DEVIATION REQUEST (Attach diagrams, figures, and other documentation to clarify request)

A deviation from the standards of or in Section **2.3.2 – Design Standards by Functional Classification, Table 2-7 – ADT** of the Engineering Criteria Manual (ECM) is requested.

PUD PRELIMINARY
SITE PLAN

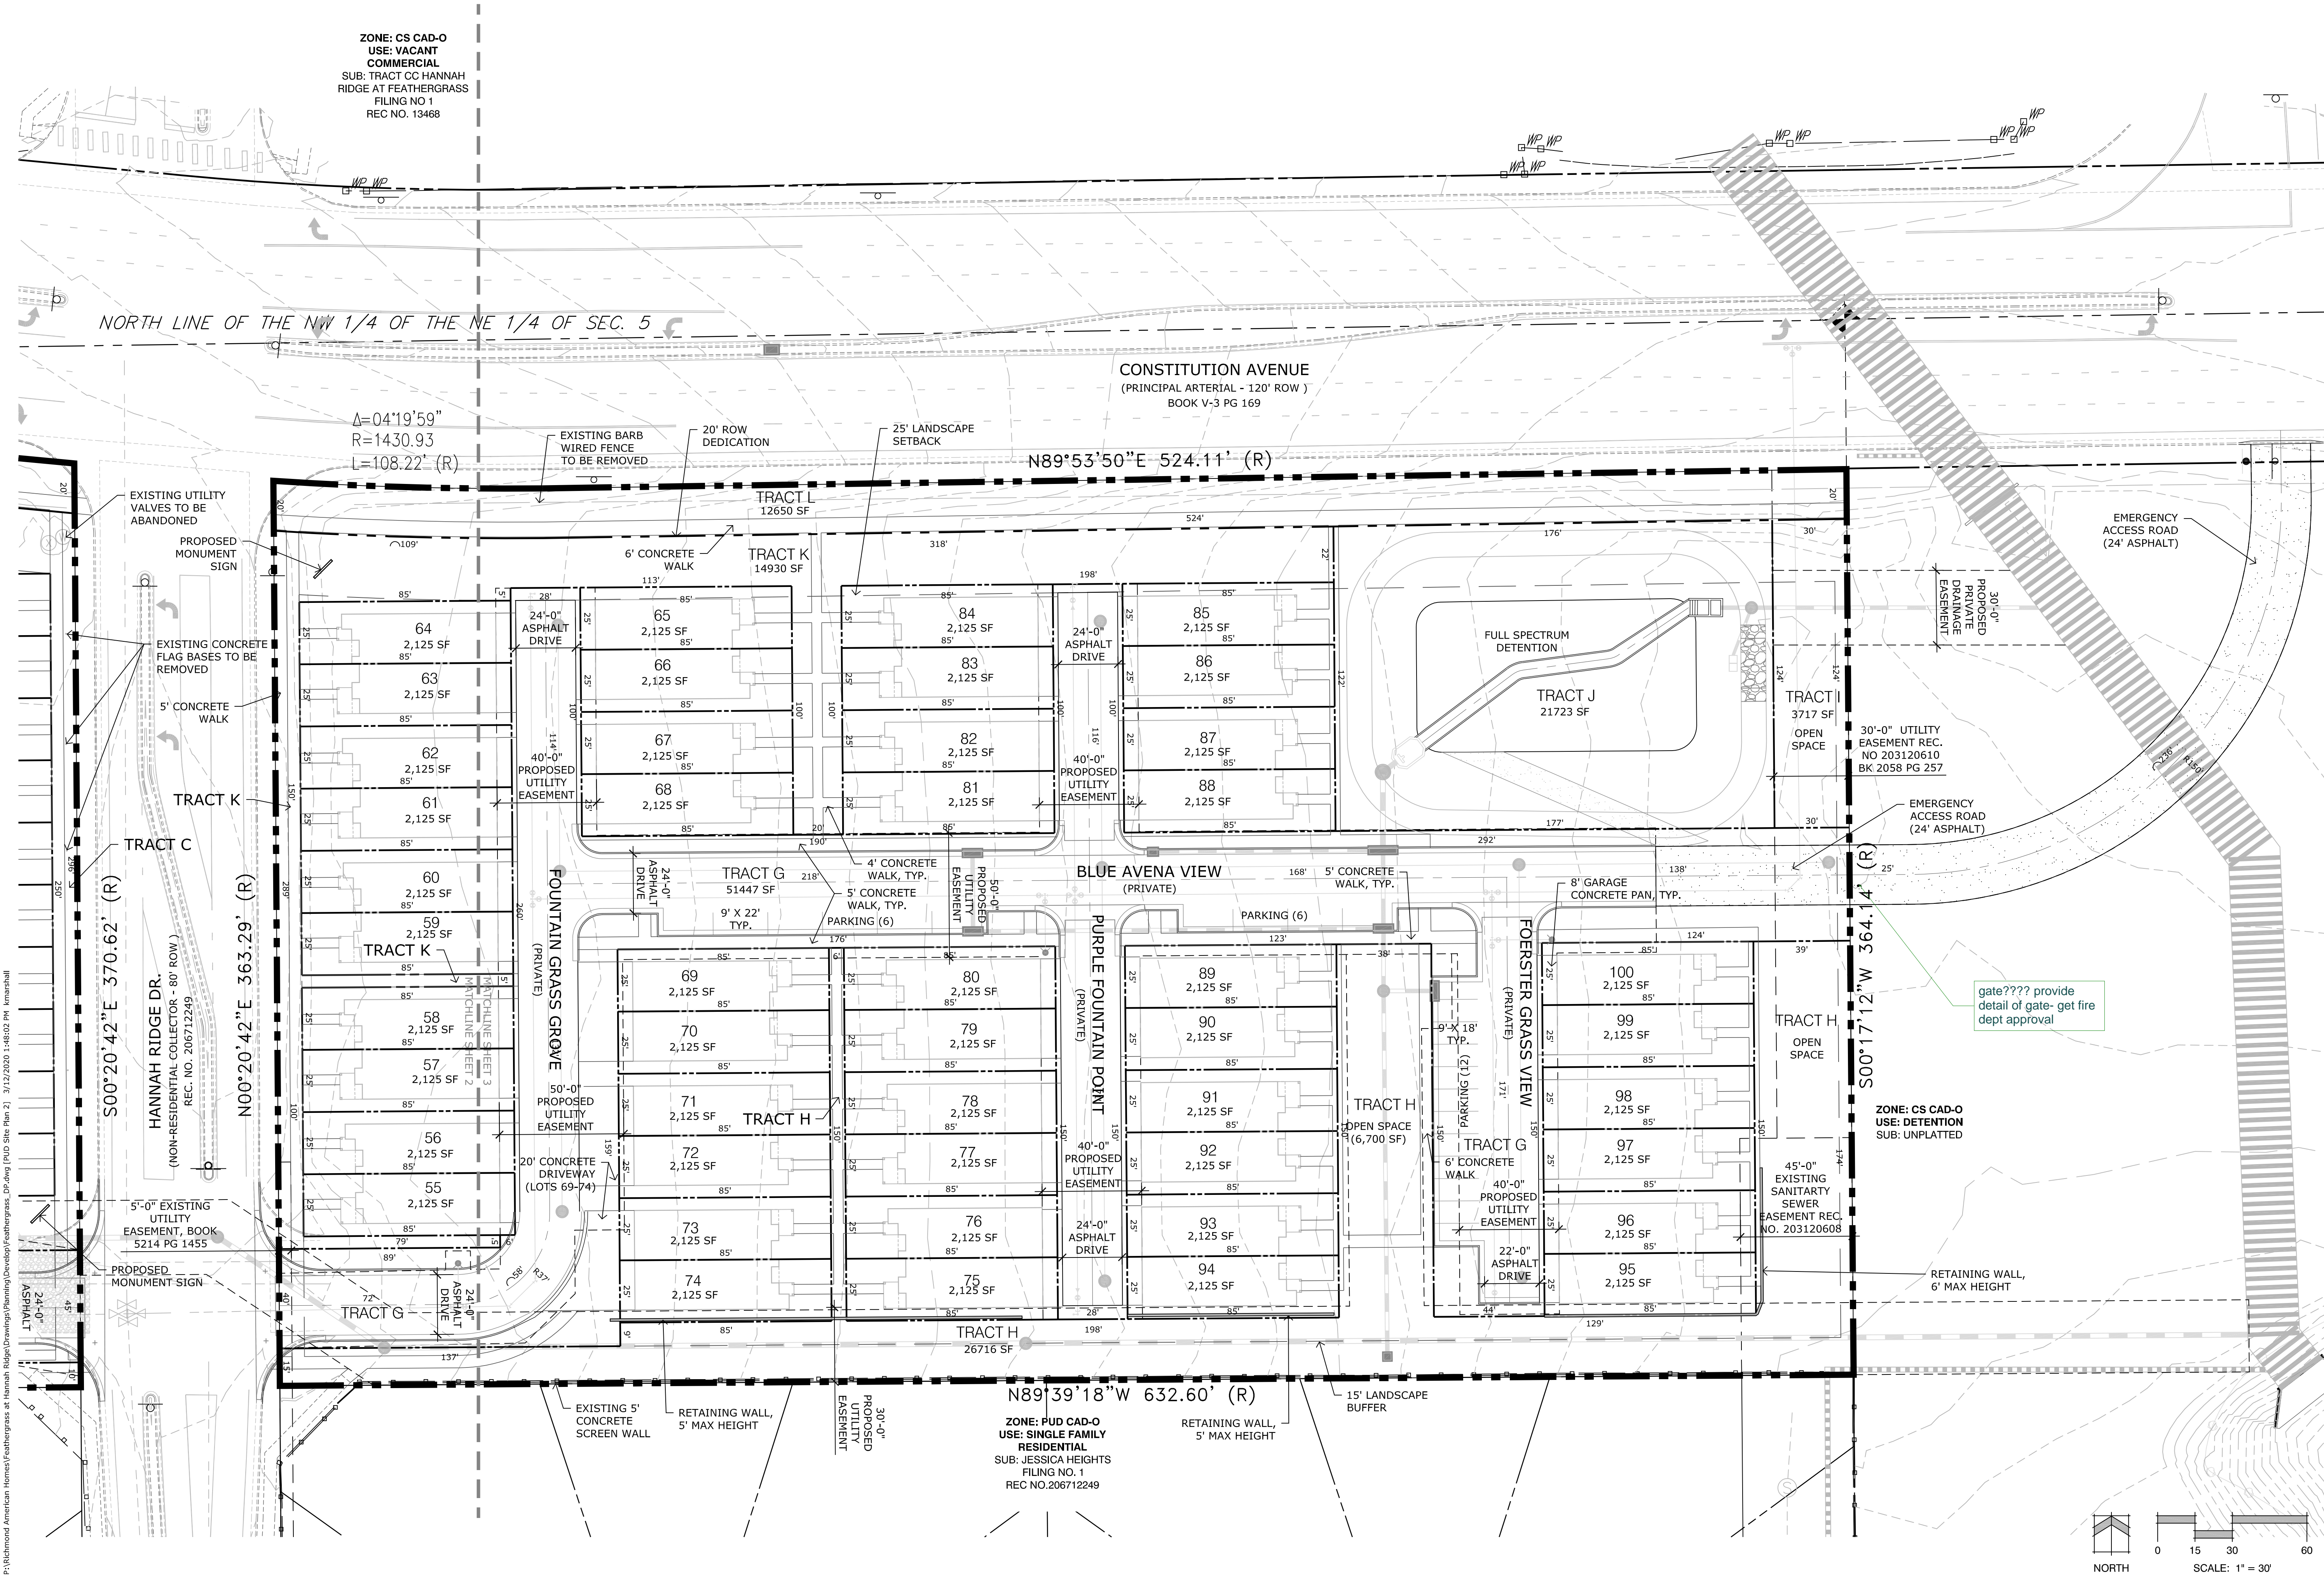
are these proposed to be public or private roads - alleys

JR Response:
Updated that they are private.
